RE: Section 75W Application - Site 4B, Sydney Olympic Park - MP 06_0273

I refer to the above Section 75W Application, which was referred to Sydney Olympic Park Authority for comment by letter dated 17 January 2011. The Authority raises no objection to the application. The following comments are made on the proposed development and the Authority considers these matters require further consideration by the Department during the assessment process:

Indicative
Site Establishment Plan
Overall Development Option

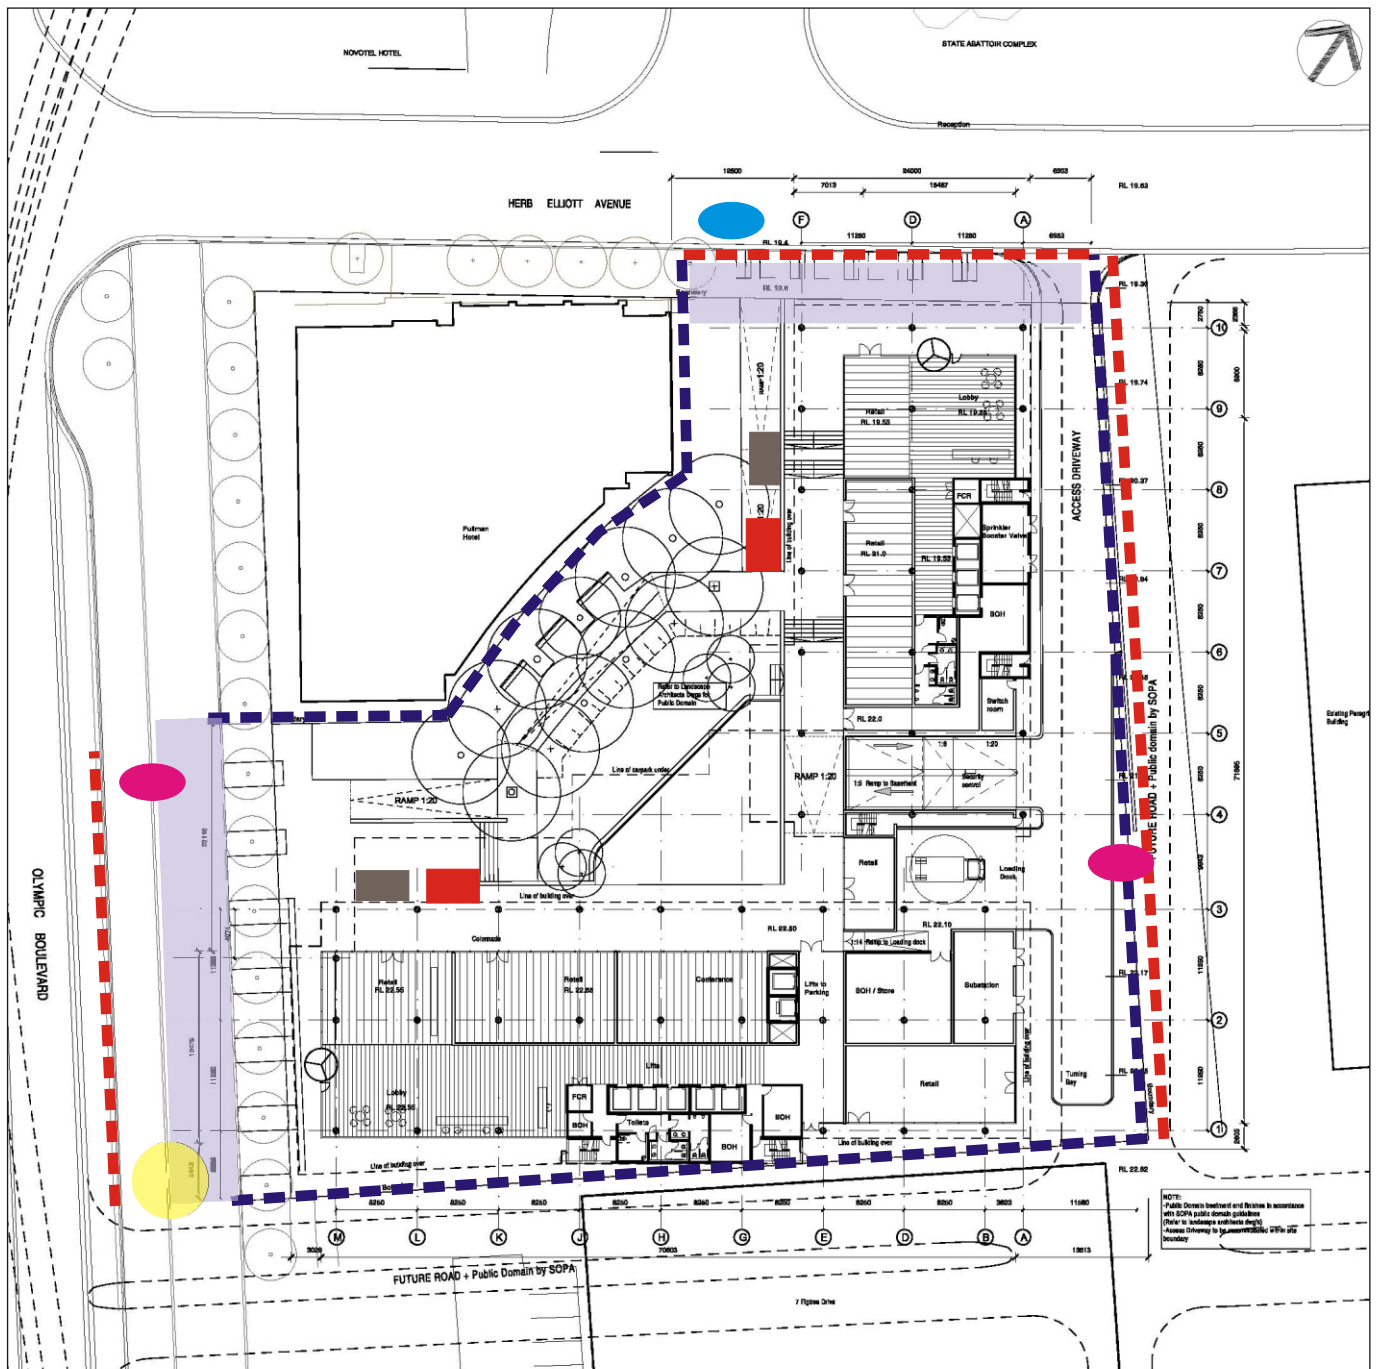
Appendix 2 of the documentation contains a Site Establishment Plan which shows a one way truck exit point onto Olympic Boulevard. Given that this is a high use pedestrian street, and subject to road closures particularly during major events, it is considered that alternative arrangements should be conditioned accordingly.

3. Revolving Doors

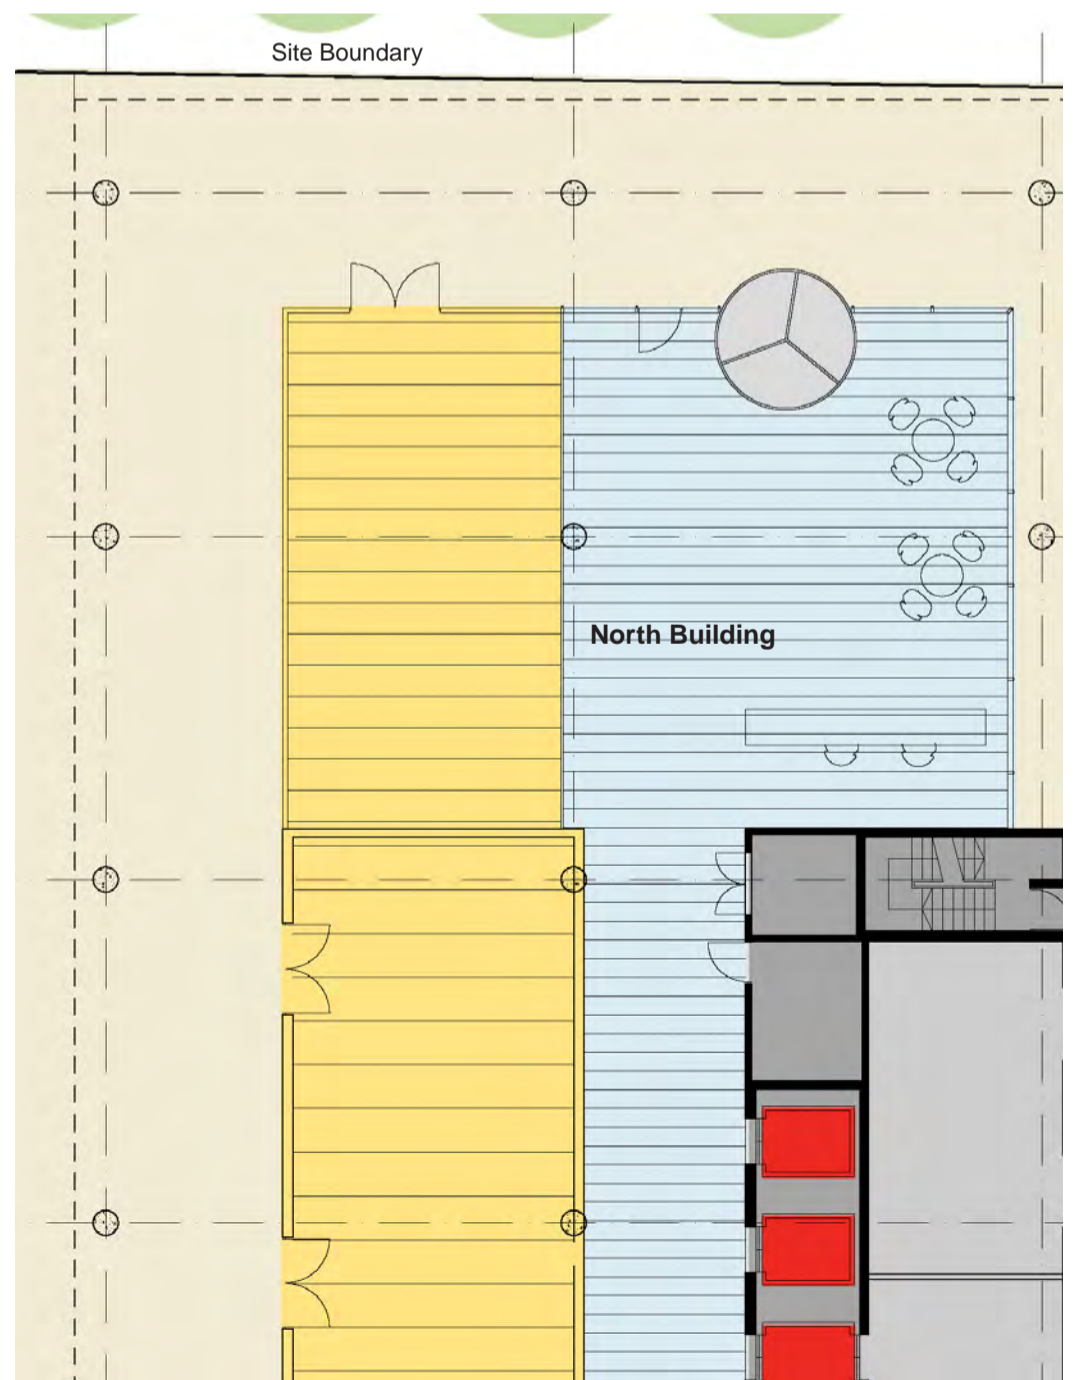
- The Revolving door on the Olympic Boulevard frontage should not project into the colonnade zone as it presents a hazard to the visual and mobility impaired.

Figure 13: Eastern Elevation

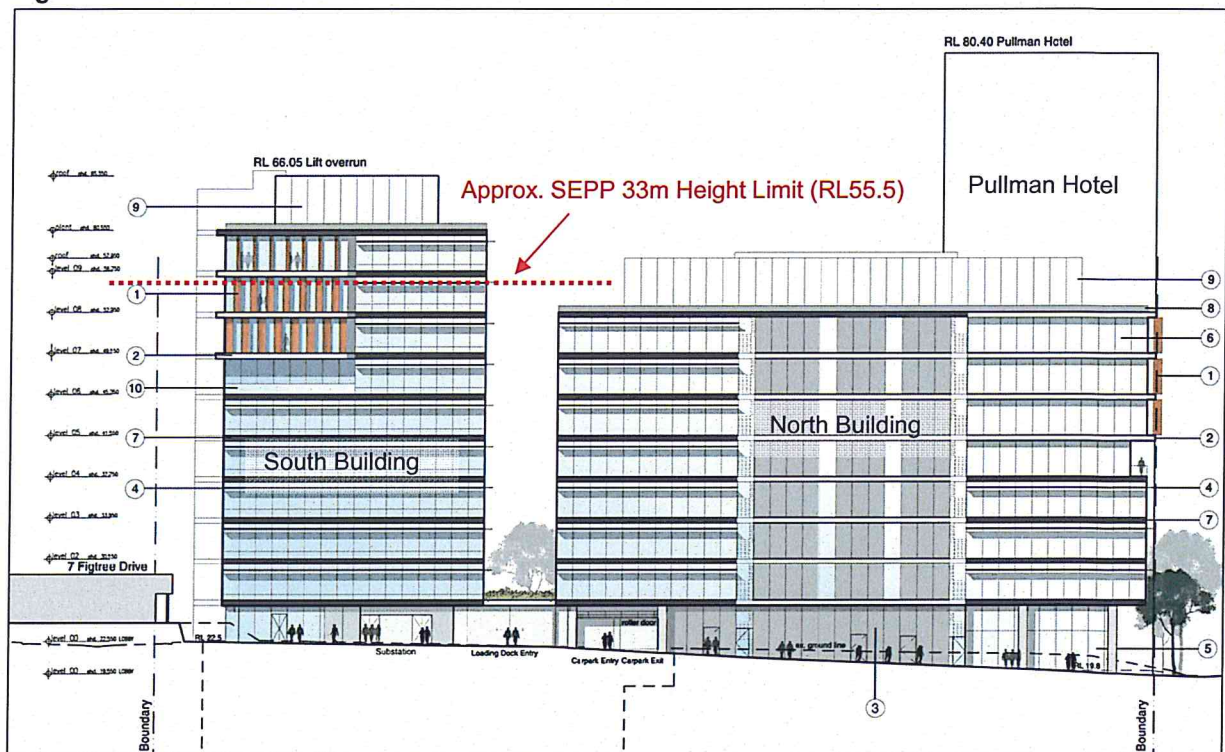
The South Building at its eastern end exceeds the 33 metre height limit by approximately 2 storeys. The documentation provided does not address this aspect of the modification. The proponent should provide justification for the additional height taking into consideration clause 21 of the SEPP (Major Development) 2005.
